Our ref: WA/2015/120640/09-L01
Int. Party ID: 10031668
Your ref: TR010019
Date: 27 January 2016

**Deadline 6 (29 January 2016) – Comments on information submitted for deadline 5
Development Consent Order Application M4 - Junctions 3-12 (Smart Motorway)**

M4 J3-12 Smart Motorway Meeting Notes Regarding Flood Risk Assessment

| 514451-MUH-00-ZZ-DR-DR-400156 | 11 |

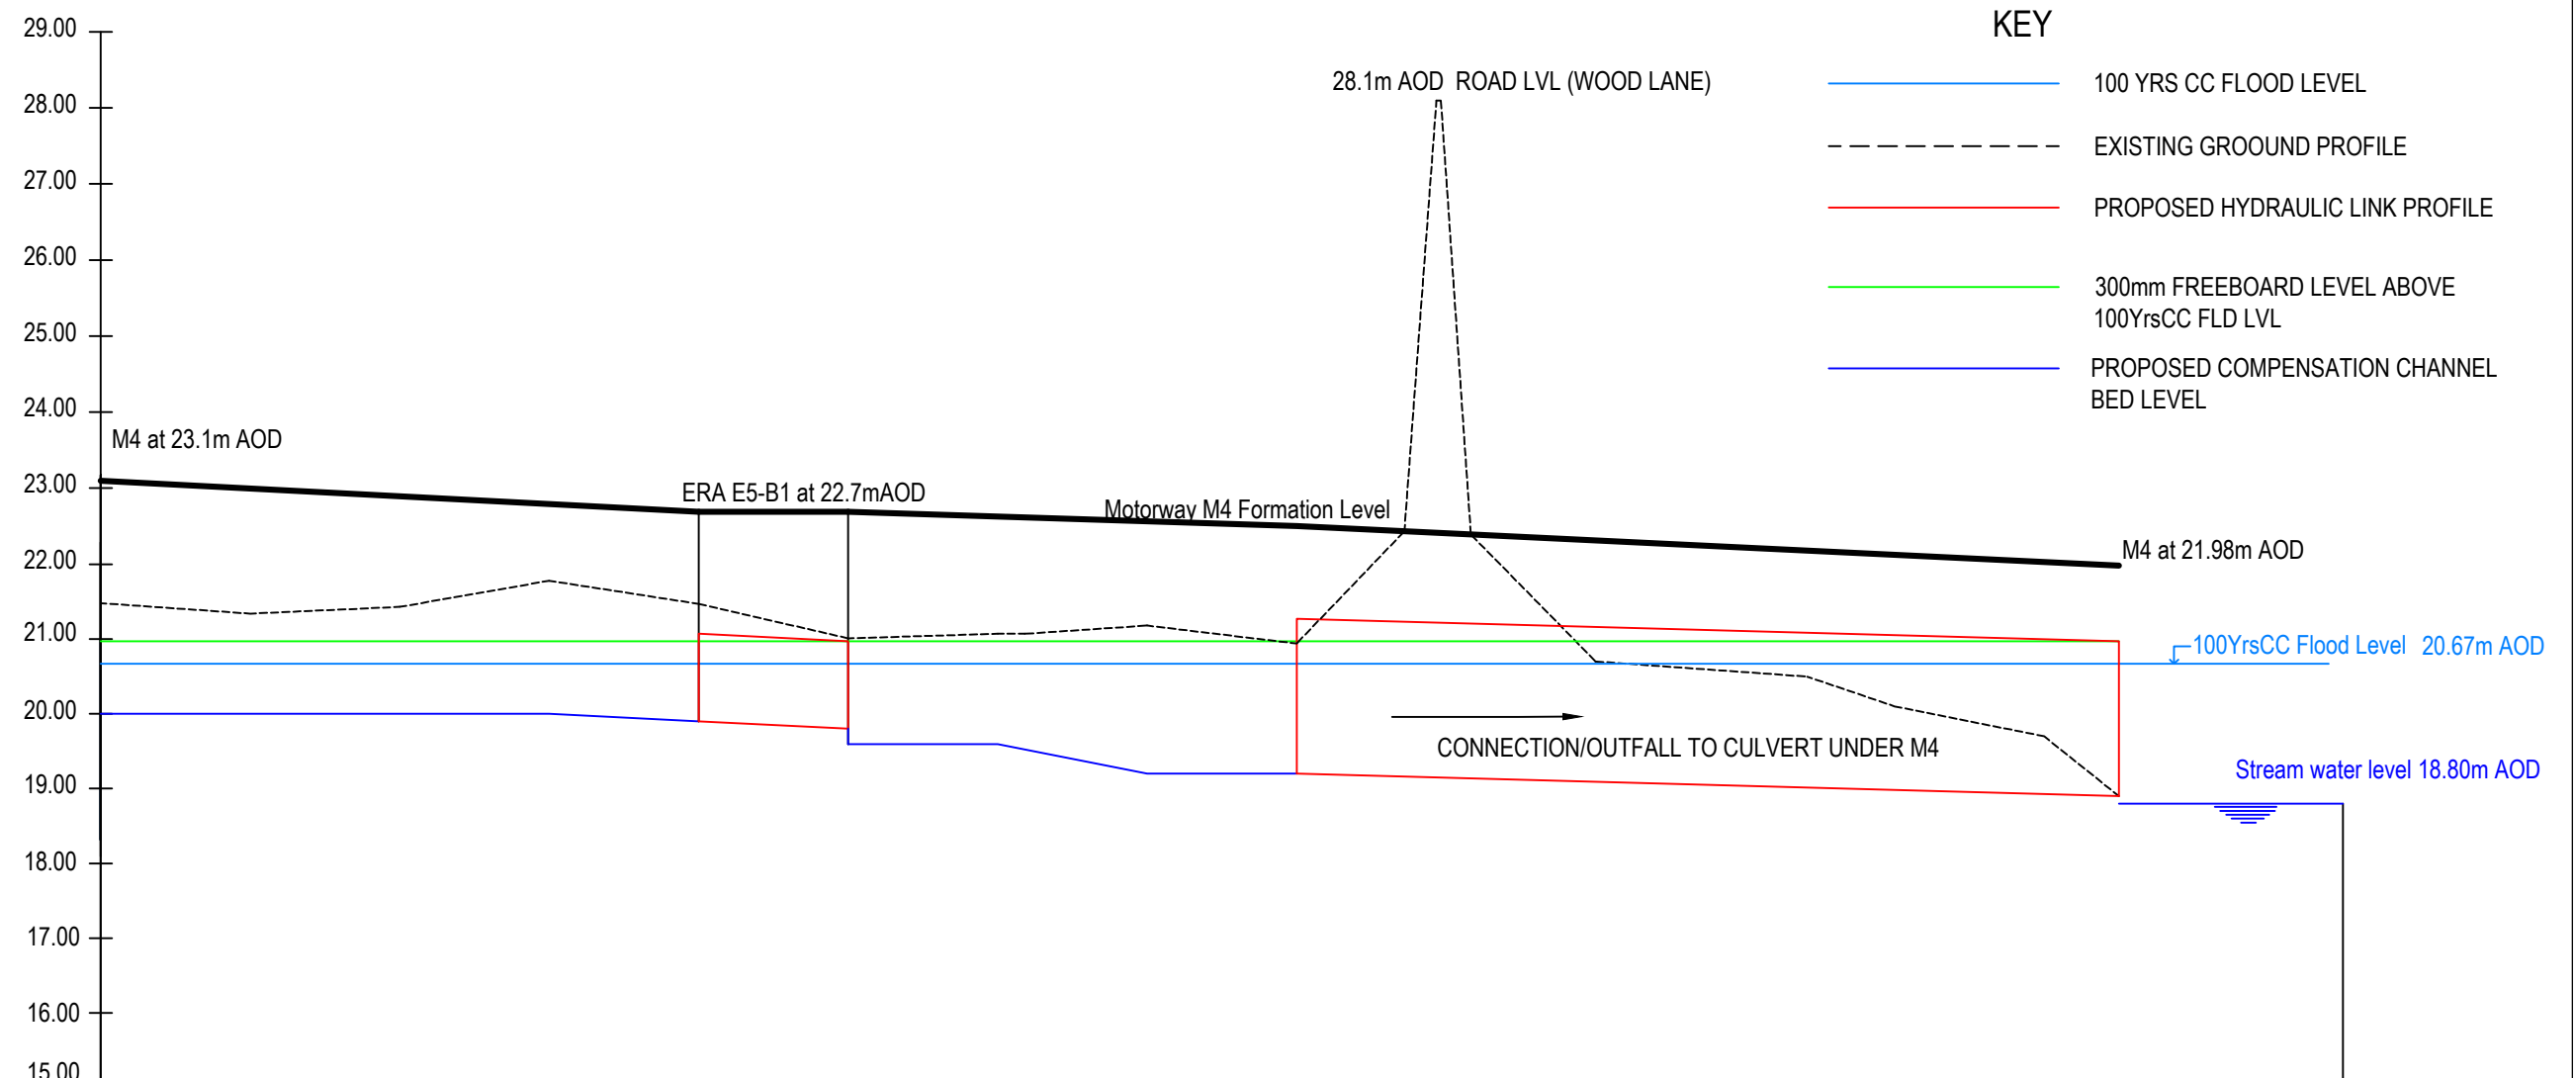
In previous submissions we have raised concerns with regards to the hydraulic connectivity of the proposed FpC areas. The January 2016 FRA sets out hydraulic connectivity on maps provided in Appendix F, detailed in the calculations spreadsheet in Appendix D and an example long section drawing number: 514451-MUH-00_ZZ-DR-DR-400192 for the site reference R18/R19 has been submitted in Appendix E, showing how the hydraulic link will work.

The FRA sets out that hydraulic connectivity for the FpC areas will be achieved using culverts and ditches, that will work under gravity and will be able to drain back towards watercourses after a flood event has receded. The FRA confirms that the proposed hydraulic links to floodplain are 'principally in the form of new ditches and pipe culverts that contain and convey flood waters during 1% AEP plus 20% allowance for climate change flood events.' Although noted correctly elsewhere in the document we would recommend that this sentence be revised to note that the hydraulic connectivity should be provided 'up to and including' not 'during' the 1% AEP plus 20% allowance for climate change flood events.

We are pleased that HE proposes to include a 300mm freeboard provision where culverts and/or pipes will provide the hydraulic link between the FpC area and the existing floodplain or watercourse. This is in accordance with industry best practice and will allow for additional height and capacity above the 1% AEP with an allowance for climate change levels.
